RESPONSE TO COUNCIL LETTER UNSW HEALTH TRANSLATION HUB (SSD-10822510)

This response has been prepared to address the letter received from Randwick City Council dated 14 October 2021.

High Street Entry - Landscape Plan

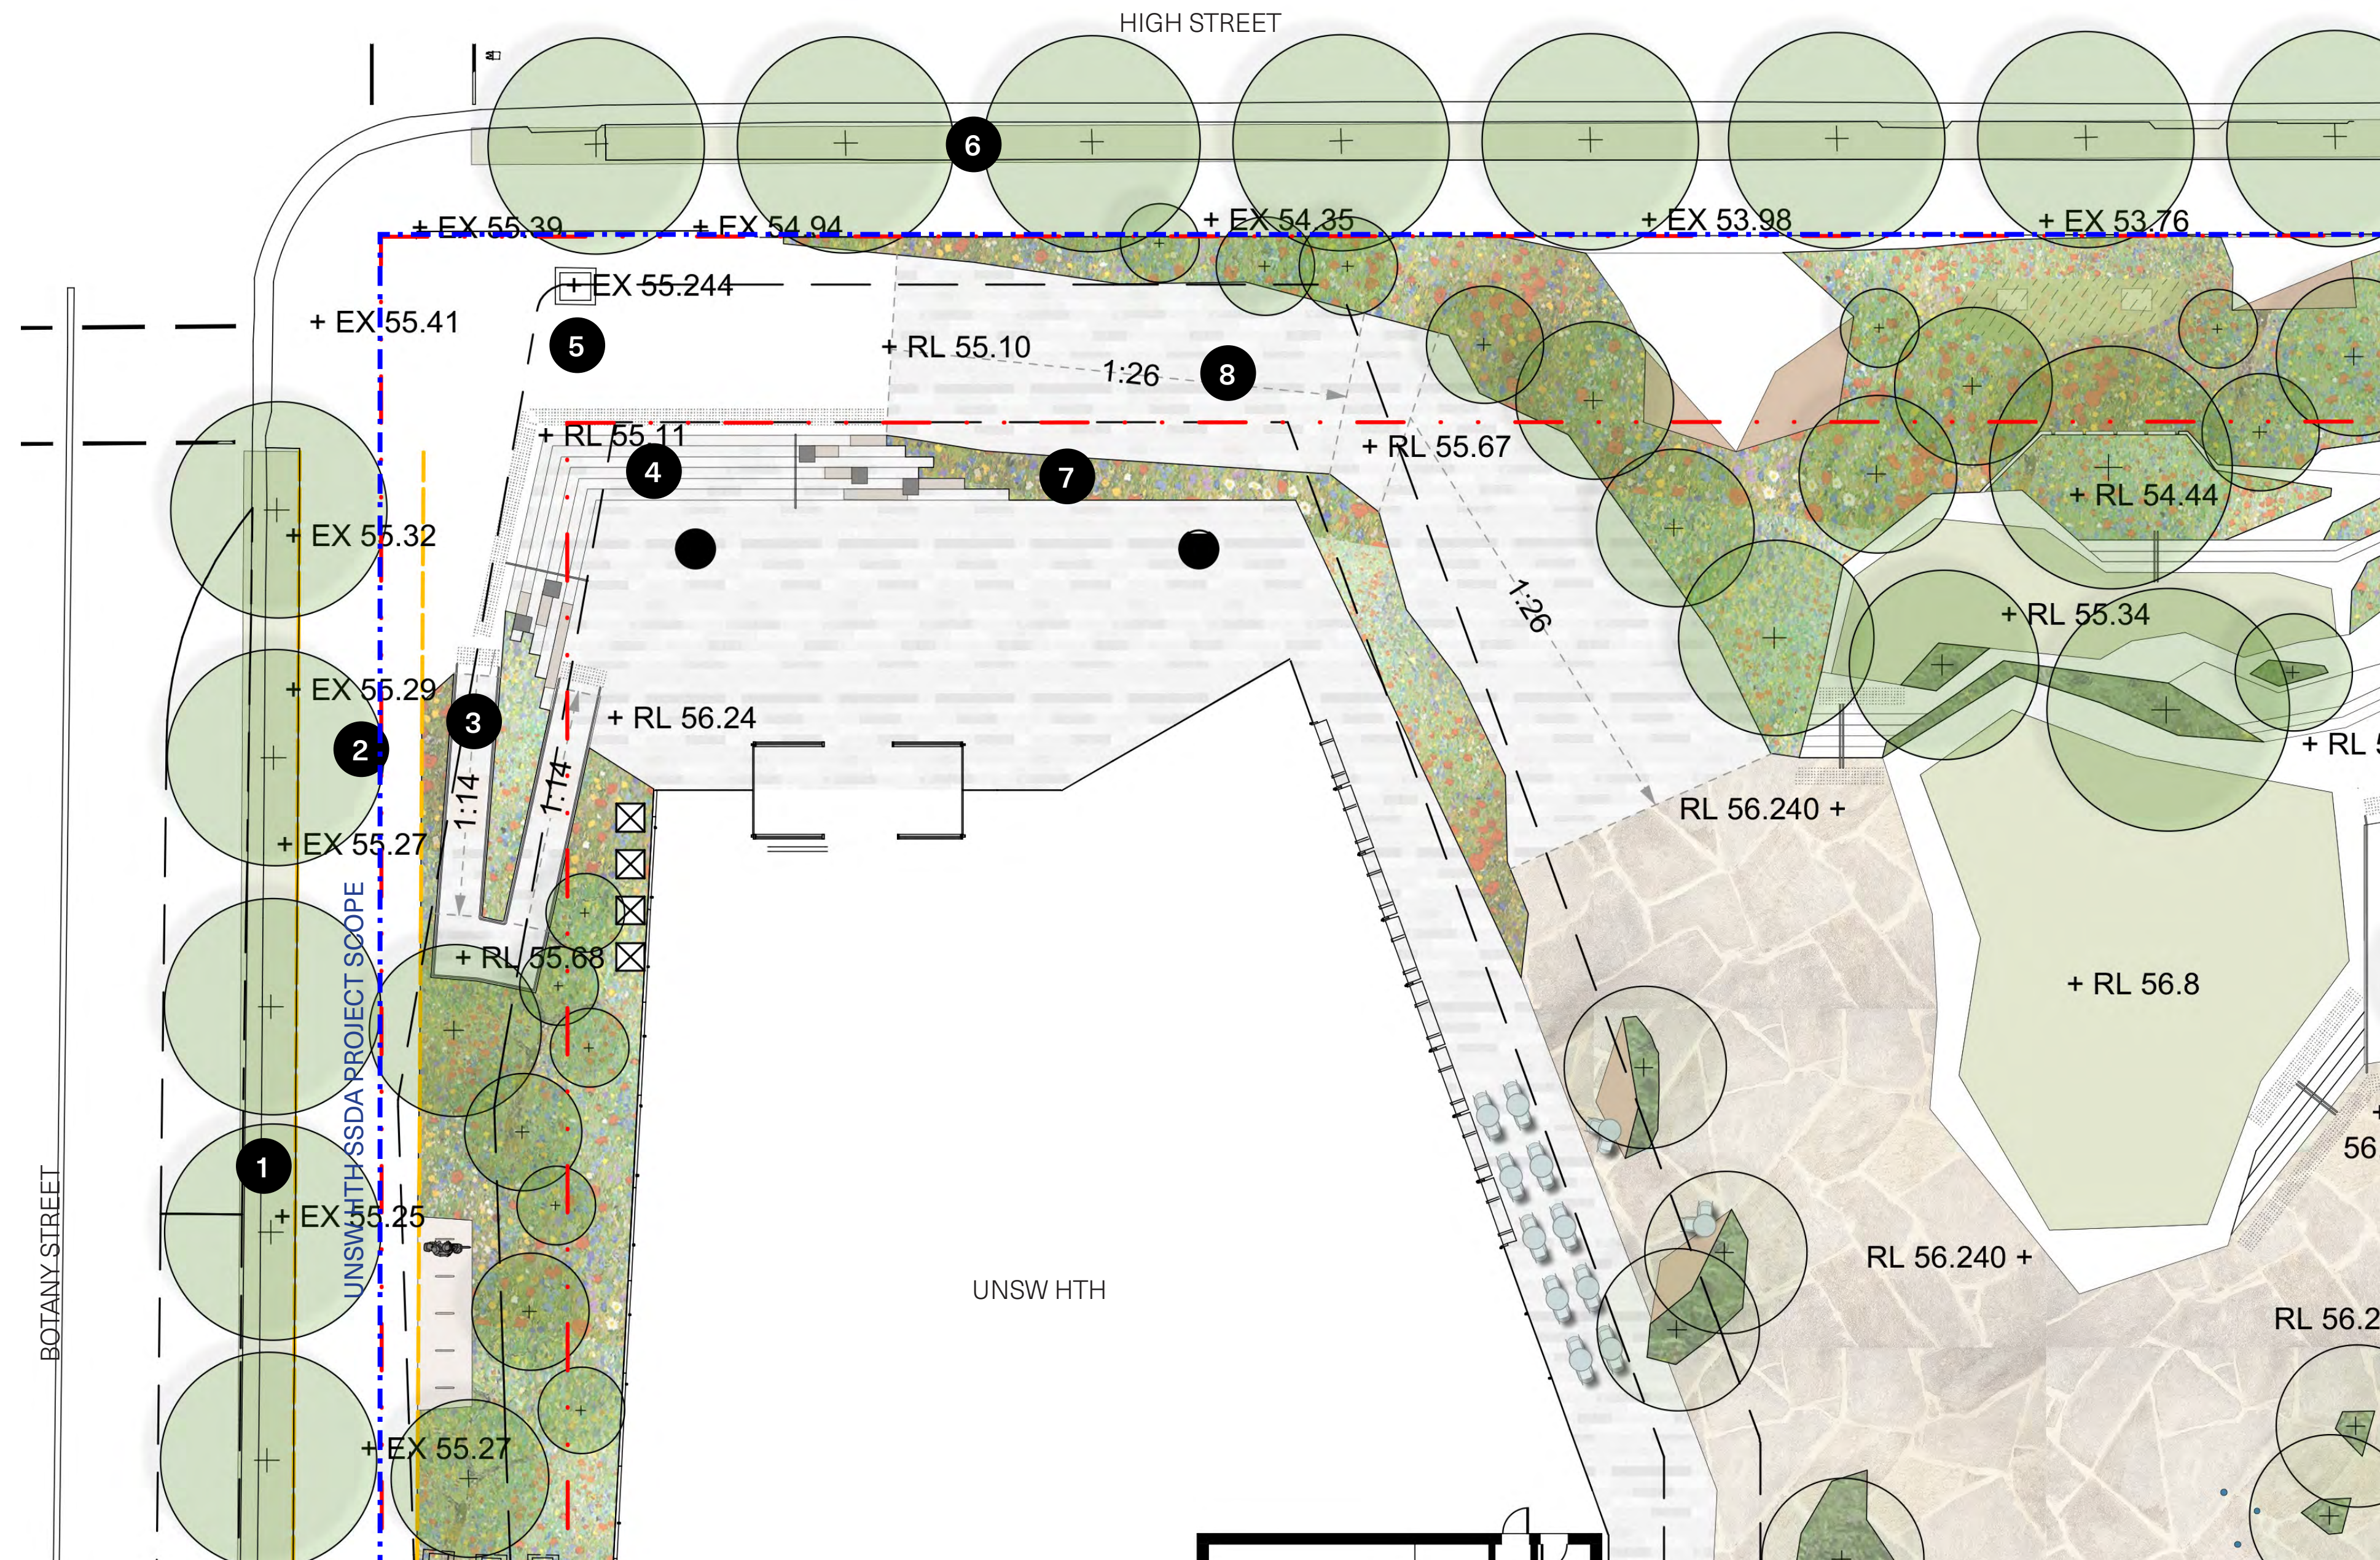
Council has maintained that the High Street footpath should be widened by 500mm to the south, to provide a footpath with a minimum width of 3m. Council has provided a draft sketch showing how this could be accommodated. Council has also provided a response to each of the points put forward in the RTS, and has suggested that the changes required to accommodate the widened pathway could be managed and would not hinder the successful delivery of the project.

- The need to integrate ramps and stairs within the overall landscape.
- Widening the footpath would result in the introduction of a 650mm retaining wall, visual clutter from additional handrails and balustrades, and the loss of trees from the landscape design. This would negatively impact the quality of the public domain, creating a series of hostile conditions on High Street which would diminish the seamless landscape transition from the High Street footpath to the public plaza. The trees that would be lost cannot be accommodated elsewhere in the site, and so canopy coverage would be reduced on the site.

- Widened the footpath would remove the landscape setback between the plaza pathway and the High Street footpath, creating a poor urban condition for the building entry as well as creating confusing and unclear precinct wayfinding.

- Widening the footpath would expose existing stormwater infrastructure that is unsightly and a potential safety hazard for pedestrians, introducing a liability risk (refer to inset image at **Figure 1**). The physical design of these inlets is unsightly and is best concealed by landscaping, as is the case with the proposed design solution. The introduction of cyclists to this pathway would heighten this risk (refer to discussion at **Section 2**).

- Given the constraints of the site and its sloping nature, necessary to accommodate flood mitigation requirements, a wider footpath would reduce the amount of deep soil available along the site's interface with High Street. This would result in a reduction of the proposed tree canopy cover and a reduction in the proposed soft landscaping along the site's High Street interface. This reduction would result in a very poor outcome for both the streetscape and the public domain, leaving very little buffer between the street and the plaza.

UNSW believes that the proposed design is the optimal outcome, and that widening the footpath would significantly reduce the public amenity offered by the proposal. UNSW has also assessed this outcome with Health Infrastructure, both UNSW and Health Infrastructure are supportive of this consistent precinct approach to maintain the UNSW proposal as submitted. In summary:

As noted, Council has provided a sketch indicating how the widened footpath could be accommodated. A mark-up of the sketch, demonstrating the implications of the suggested design, is provided at **Figure 1**. The existing stormwater infrastructure that would be exposed is shown in the bottom right of the image. For comparison, the UNSW HTH landscape response is provided at **Figure 2**.
